RE: PLANNING APPLICATION FG/59/19/HH
PIED A TERRE, FERRING STREET, FERRING. BN12 5JW

I write to object about the size of the proposed first floor extension to the old Police House on the corner of Onslow Drive and Ferring Street. It is gross over development of the site and totally out of character with the adjoining bungalows.

Proposed Ground Floor Plan

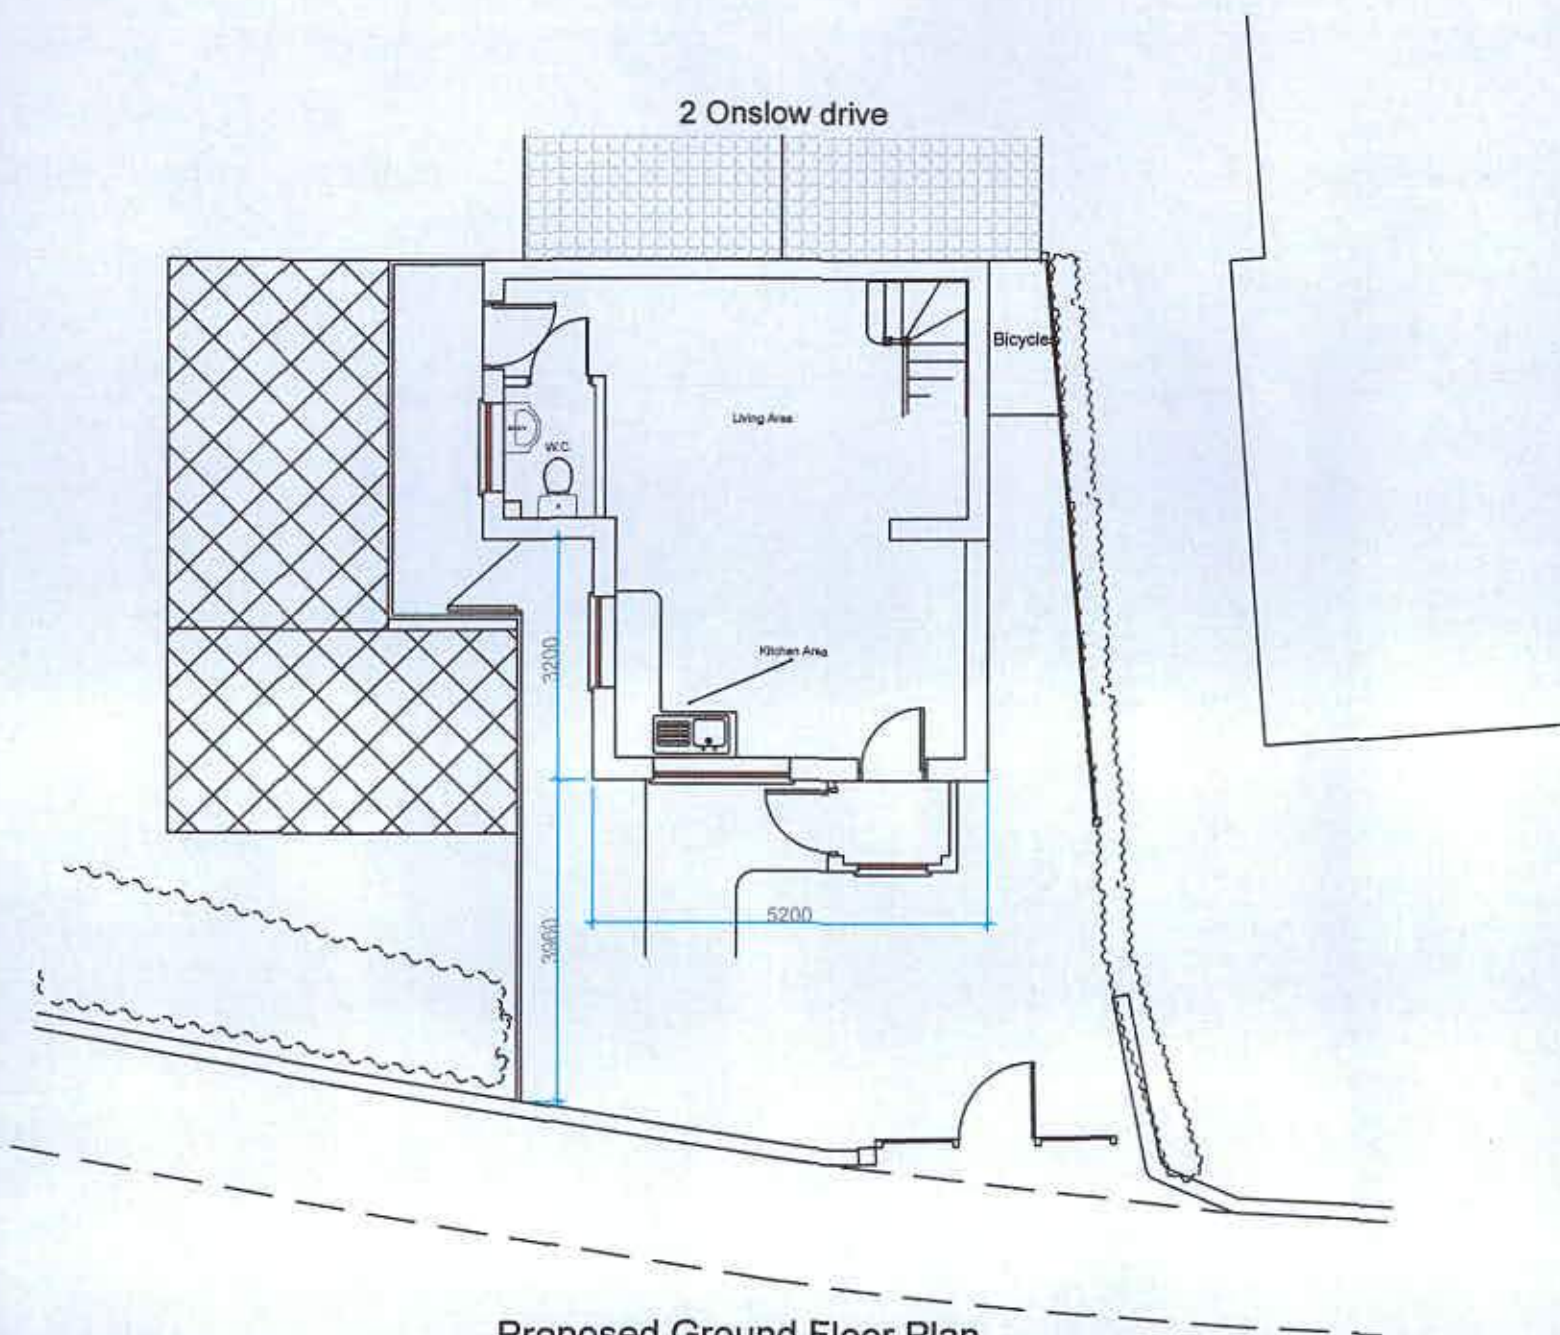
There is no garage space! If a couple buy the property and each own a car, where will they park? It is difficult enough in this village to find a space to park when trying to shop, without property owners parking on the roadside. This is detrimental to the shopkeepers, who have a hard enough job to make a living as it is.

Proposed Street Scene (East)

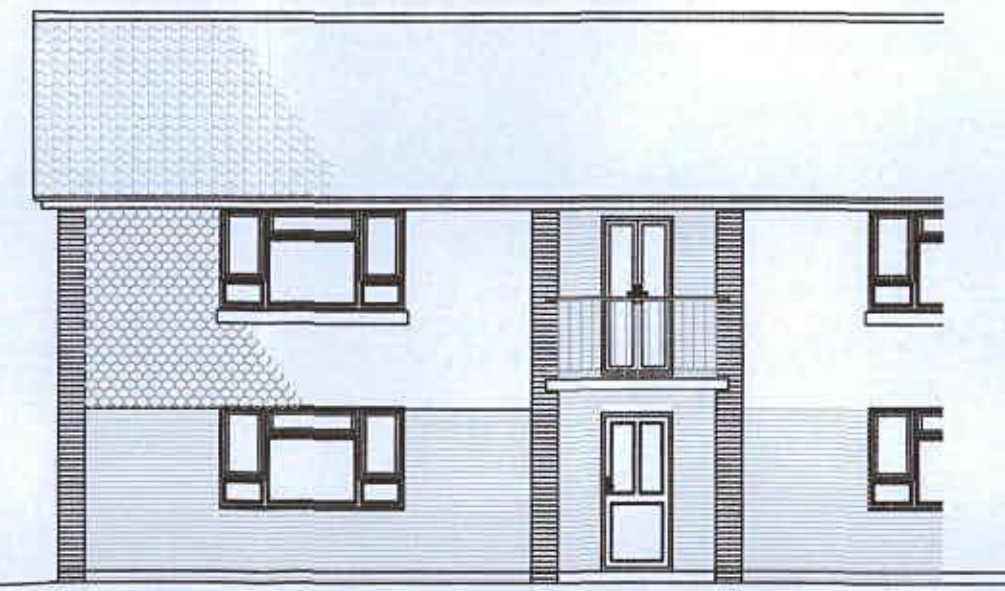
The granting of a first floor extension will affect its immediate neighbour and the owners of Pump Court, 39 Ferring Street. Whilst one doesn't buy a view, I believe the first floor extension is detrimental to the mental well being of the people in Pump Court, as all they will see is a blank wall, with one small window, and be deprived of sunlight which we all need to live a healthy life.
